# Norfolk Boreas Offshore Wind Farm Applicant's Comments on Deadline 4 Submissions and Additional Submissions

Applicant: Norfolk Boreas Limited  
Document Reference: ExA.ASR.D5.V1  
Deadline 5

Date: February 2020  
Revision: Version 1  
Author: Royal HaskoningDHV

Appendix F - COLBY ROAD (CHURCH ROAD), NORTH OF BANNINGHAM - SITE PLAN AND PHOTOGRAPHS

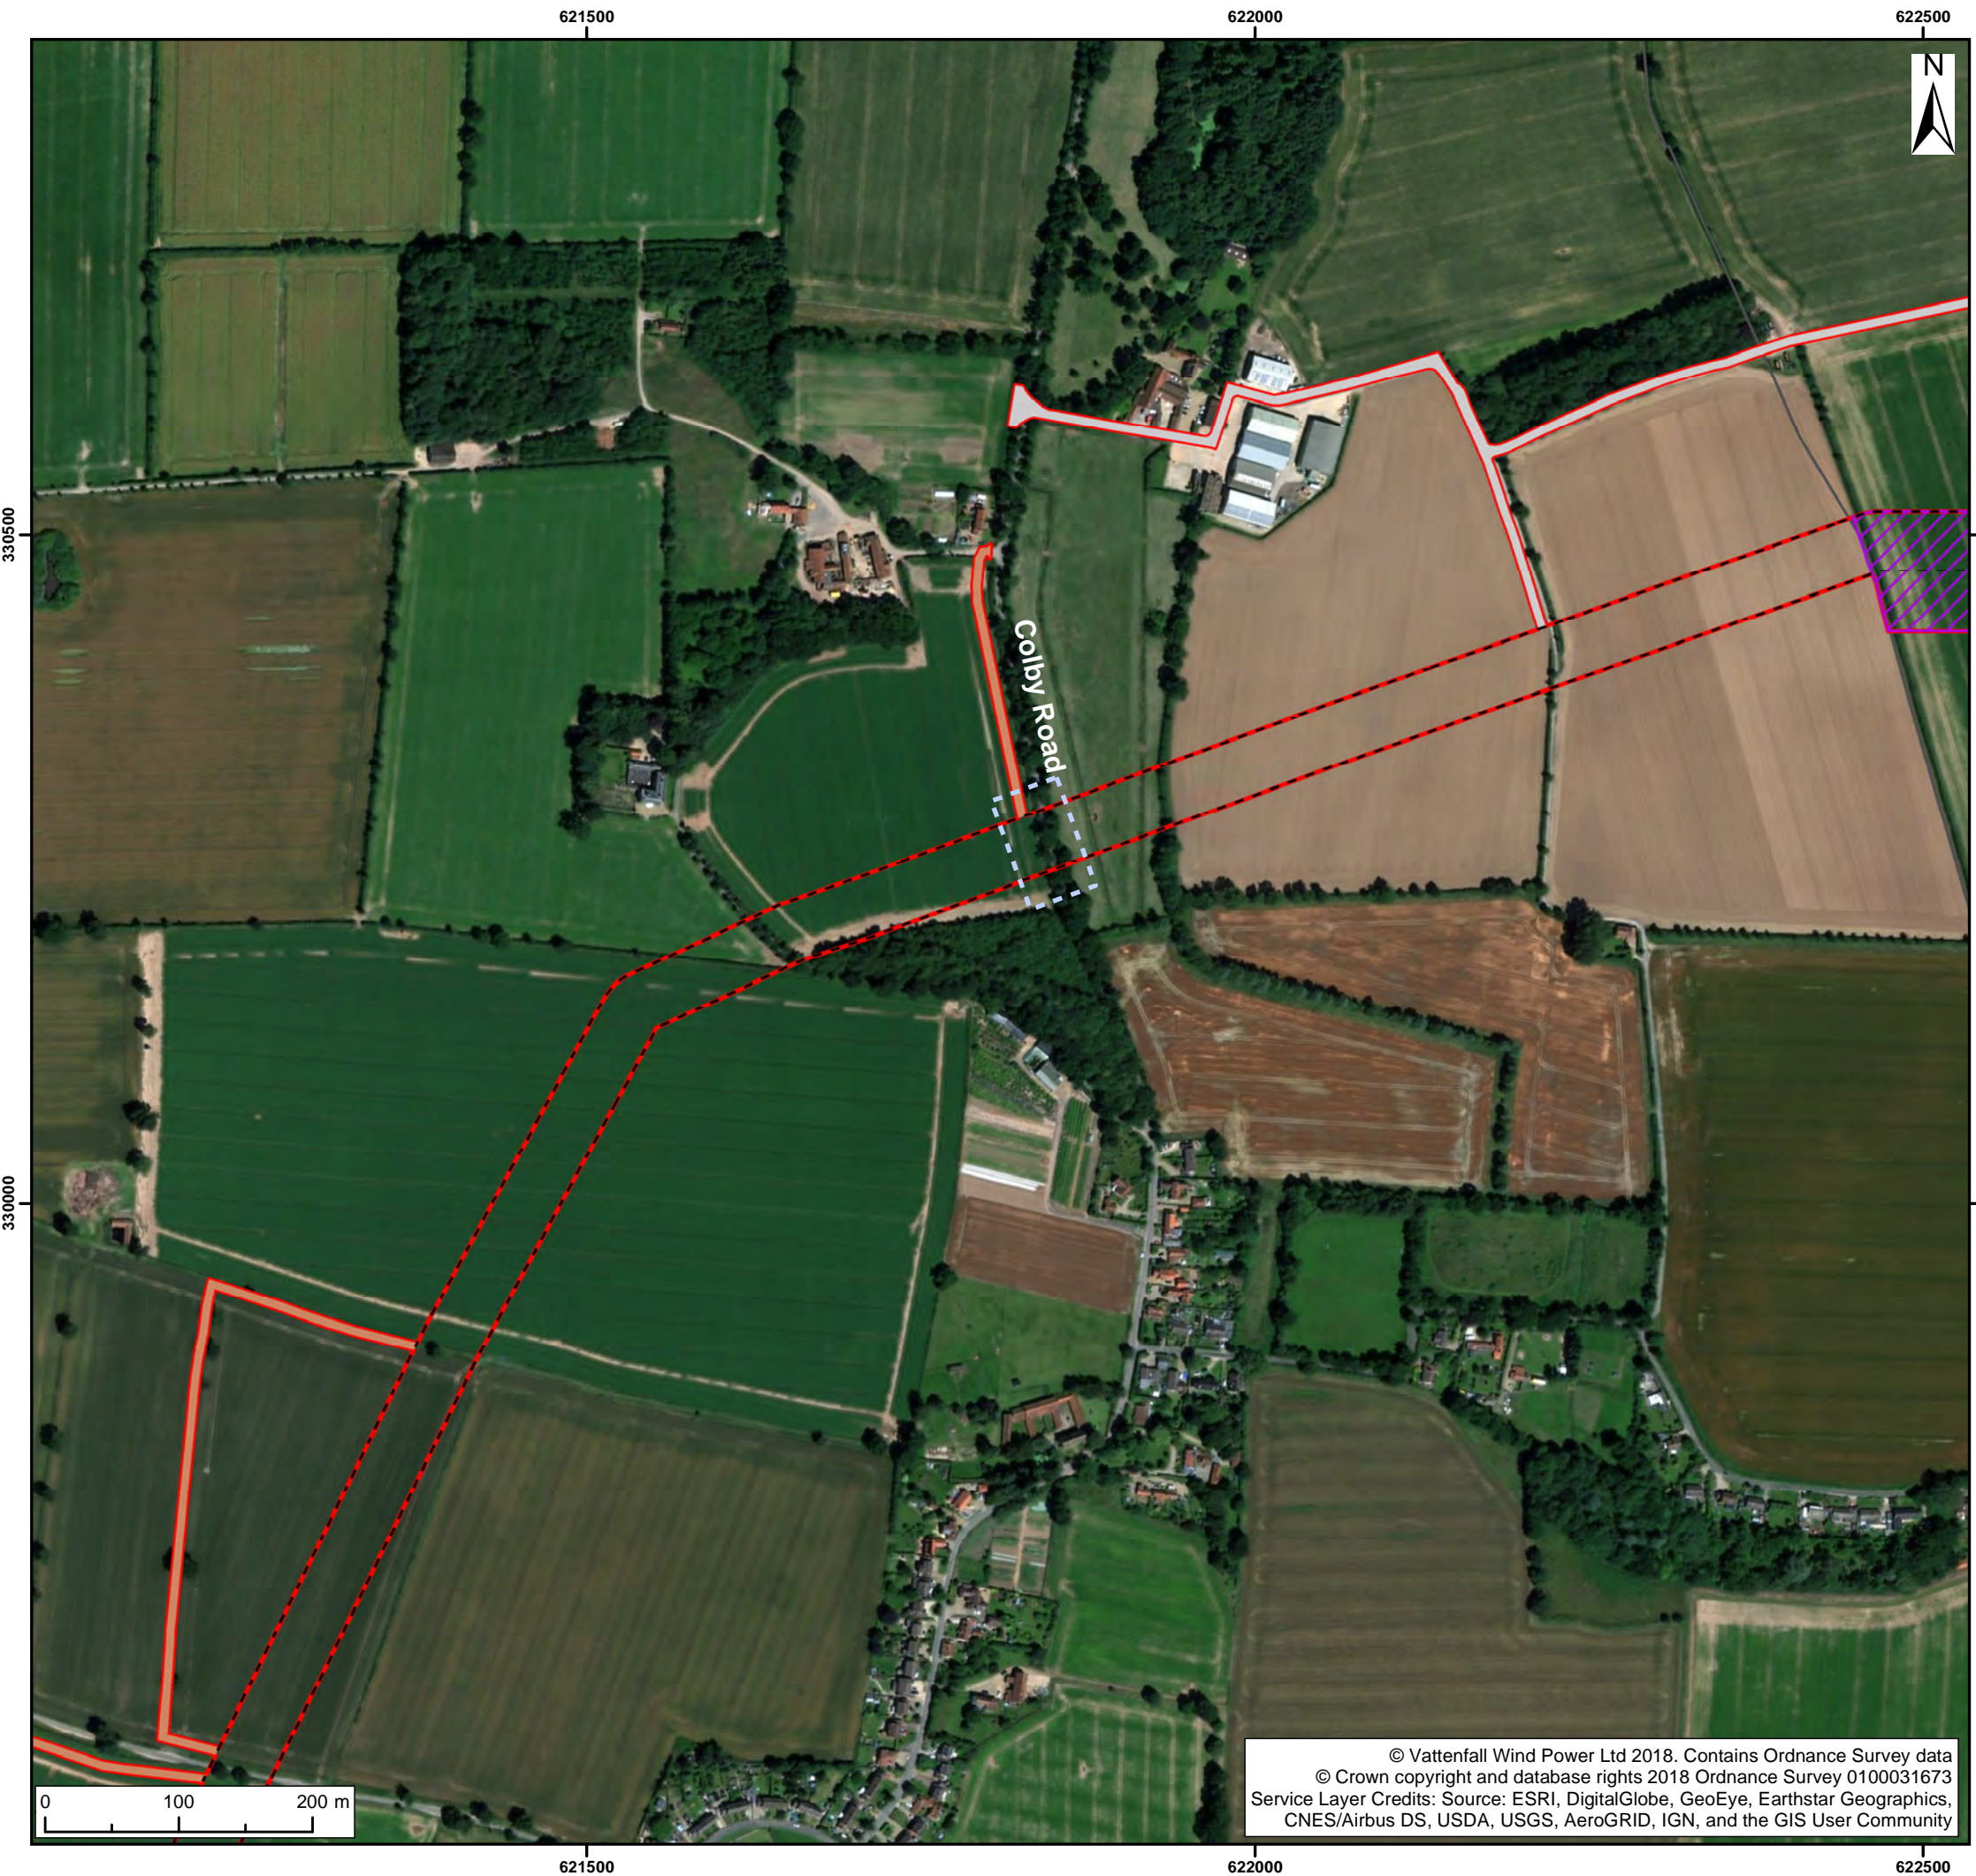
<p><b>Trenchless crossing at Colby</b></p> <p>NNDC welcomes the Applicant's oral submissions. NNDC's position remains that the environmental and landscape impact of removing the trees at Colby (see the photos at Appendix F of NNDC's LIR REP 2-087) would have a significant effect.</p>	<p>Noted. The Applicant submitted a Clarification Note on Trenchless Crossing at B1149 and Church Road Colby, at Deadline 4 [REP4-017].</p>
<p><b>Outline Traffic Management Plan</b></p> <p>NDC's view is that the Outline Traffic Management Plan should be further updated, particularly regarding additional mitigation at Little London Road.</p> <p>Additional updates on traffic management, mitigation for works within the more sensitive non-standard construction hours including unexpected and extended duration working in specific locations would be required.</p>	<p>The Applicant has provided further information on the Little London Road crossing in response to Q2.14.3.11 to the Examining Authority's further Written Questions at Deadline 5 in document ExA.FWQR.D5.V1.</p> <p>Mitigation measures for Little London Road are detailed in Table 4.3 of the OTMP [REP1-022].</p>
